25 August 2014

Objections to The University of Sydney's Response to Submissions June 2014 in regard to Campus Improvement Program 2014-2020 (CIP), State Significant Development Application (SSD 13_6123)

01 HEALTH - SECTION 1 PROPOSED

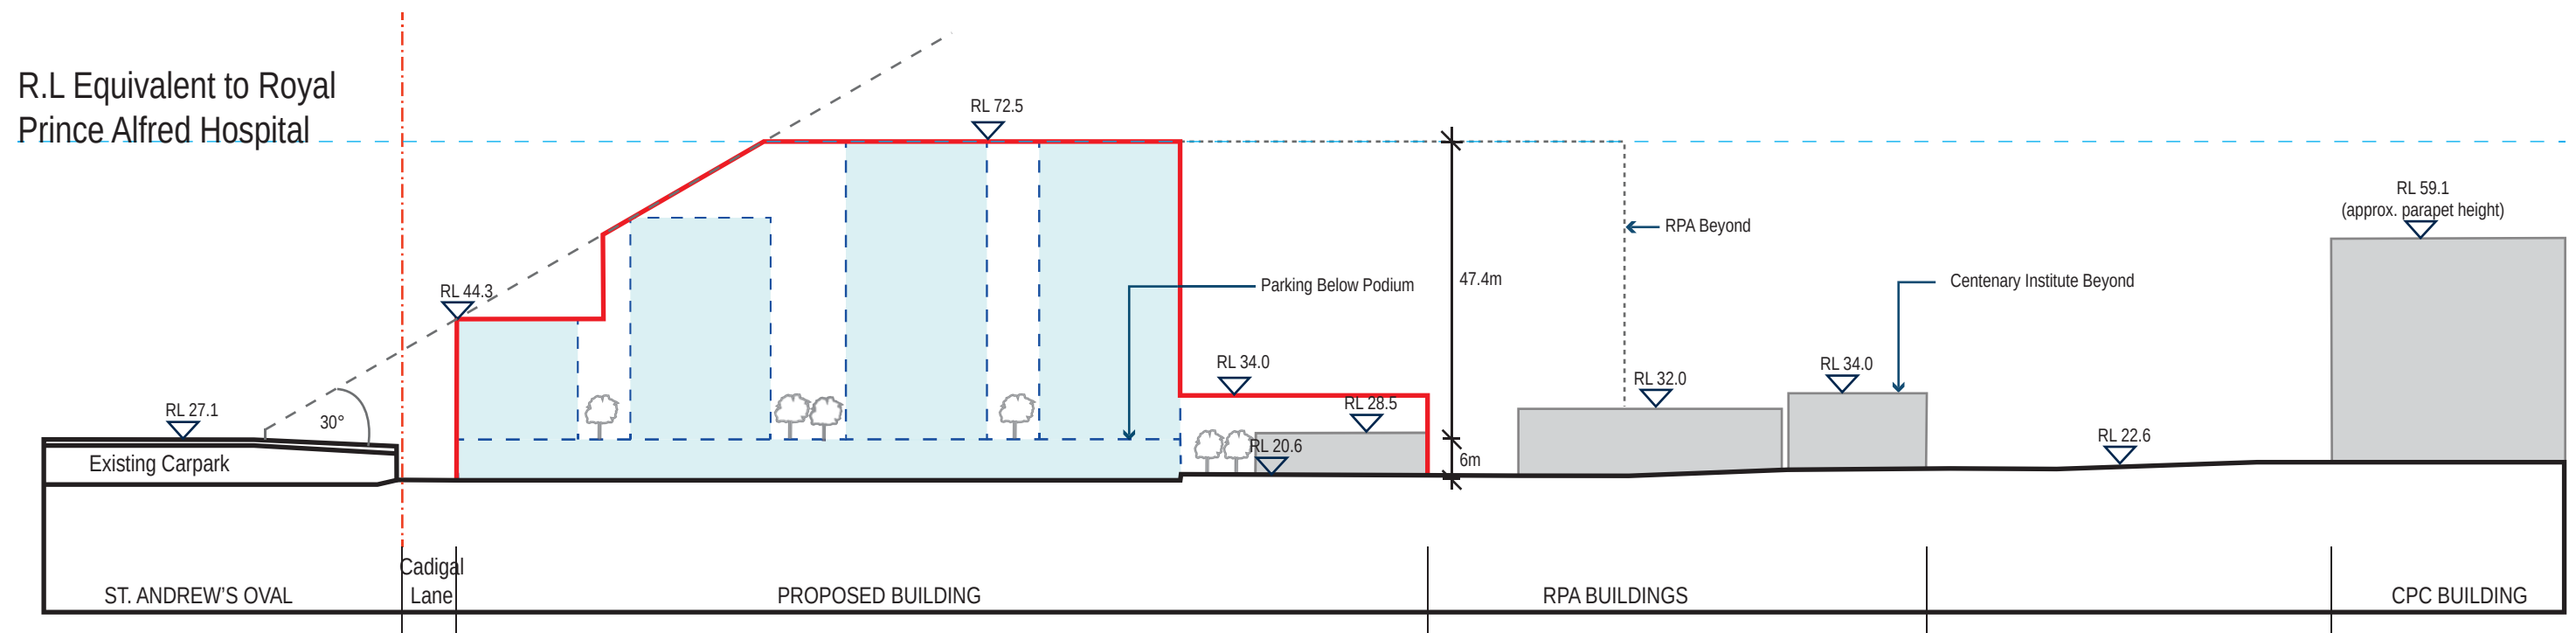
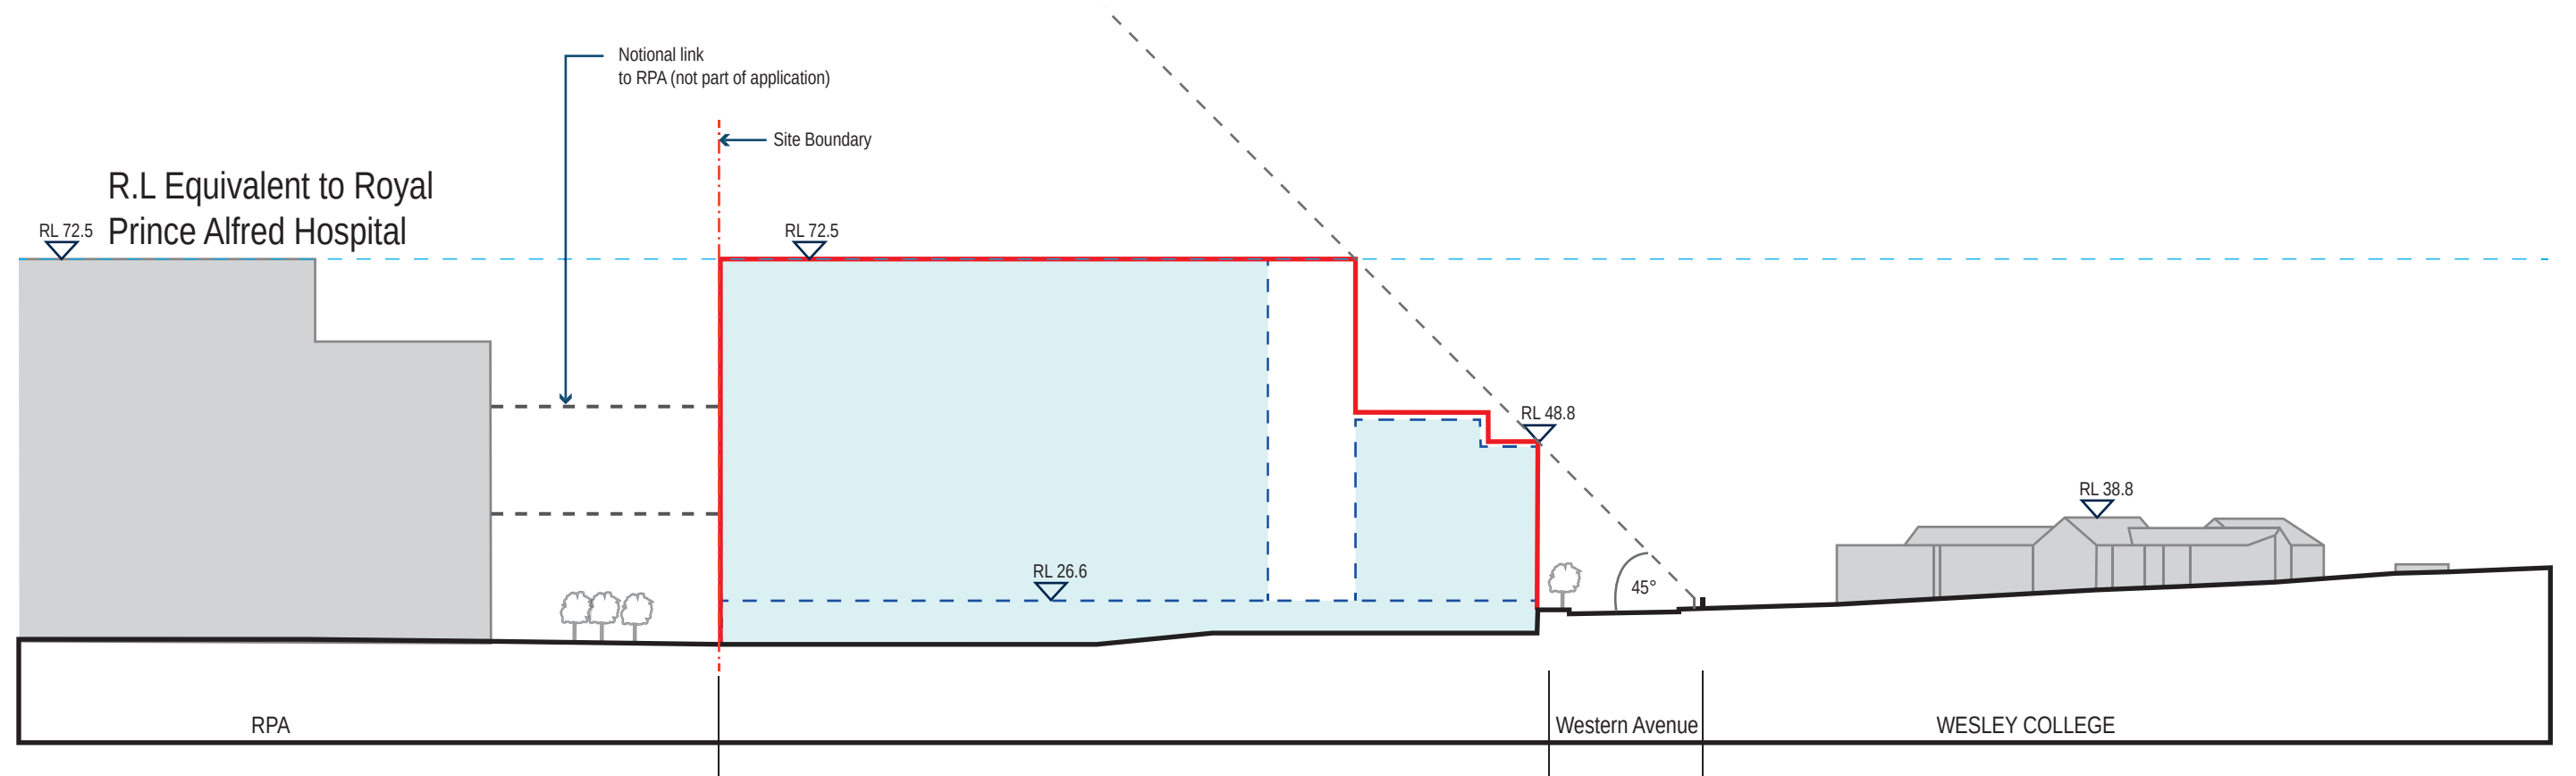
UOS responds that the CIP HP height has been reduced "to match that of the adjoining RPAH". This is not really the case, because SLHD's original objection referred to "surrounding RPA buildings, in particular Gloucester House and the Clinical Services Building (CSB)".

The apparent reduced height appears to match E-Block which has its entrance on Missenden Road (at RL 72.5), not the CSB (at RLs of 59.1 and 63.4) adjacent the UOS boundary. Gloucester House is lower still at RL 47.7.

Further, the section on UOS Drawing SSD-E-12 RevA shows RPA's equivalent/ determining height as RL 72.5 from south to north, which is misleading because the RPA CSB is actually RL 50.6 at the northern end, based on the UOS survey. Also, the section on Drawing SSD-E-13 RevA is also ambiguous because it implies an adjacent RPA building of RL72.5 rather than an actual RL 63.4.

The top of the CIP HP envelope should reflect the existing CSB and Gloucester House levels, or the recently approved Charles Perkins Centre, rather than E-Block which is out of context.
